We have received the attached in response to your comments of 03/11. They state that *"We have included the plan alongside the site wide drainage plan for context. We accept these works may need to be adjusted if required by the final site wide drainage strategy, although we trust this is now suitable for variation of the above conditions."*

From: Laura Gibbons <Laura.Gibbons@arun.gov.uk>
Sent: 03 November 2020 14:25
To: Planning.Responses <Planning.Responses@arun.gov.uk>
Cc: Simon Davis <Simon.Davis@arun.gov.uk>
Subject: Y/99/20/PL

Engineers Comments Regarding Surface Water Drainage

TITLE Area of Junction Within Site Boundary

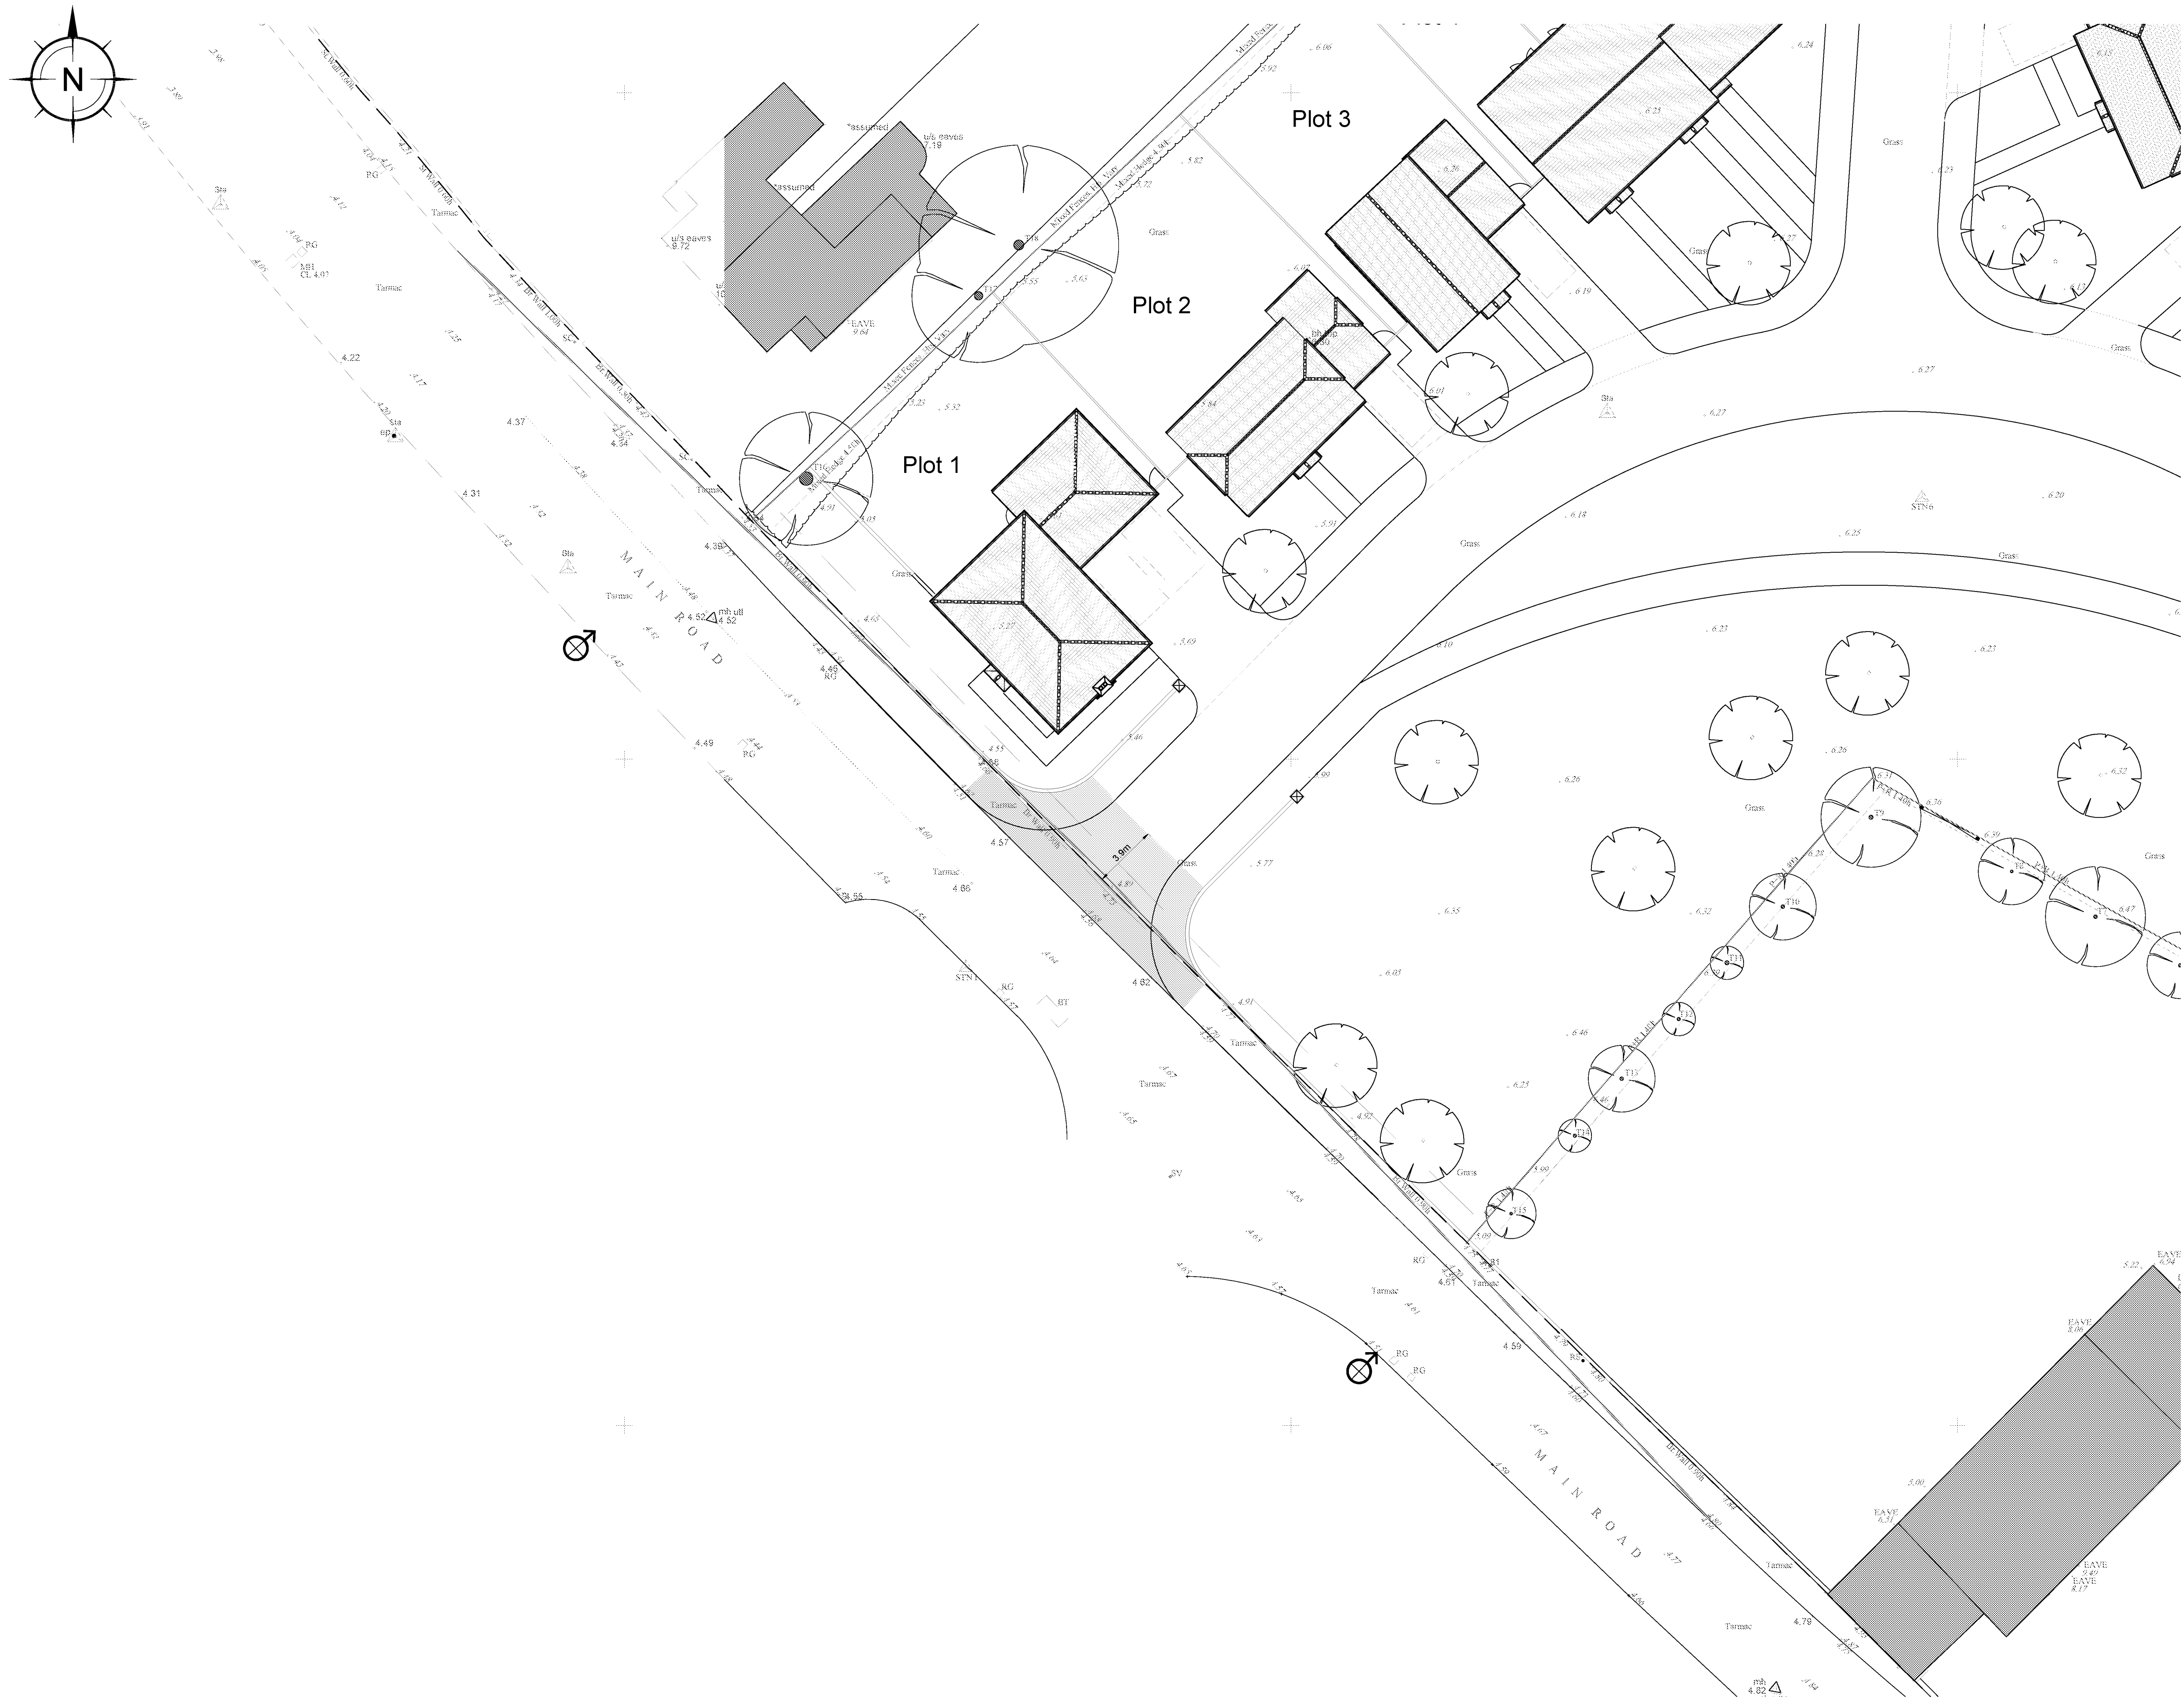
We do have some concerns regarding this application to vary the drainage conditions. The area in the plan referenced within the proposed condition rewording is part of the wider surface water drainage storage area for this site. This area should have a permeable construction. Please can the applicant submit a detail evidencing that this will be the case. This is required to ensure that the access way will not result in highway flooding.

It may be that the access way will have to be reconstructed if the drainage strategy is changed substantially. Please can the applicant acknowledge that if necessary they would make any necessary adjustments to the construction after agreement of the drainage strategy.

Thank you. That is acceptable. We therefore have no objection to the variation of the condition.
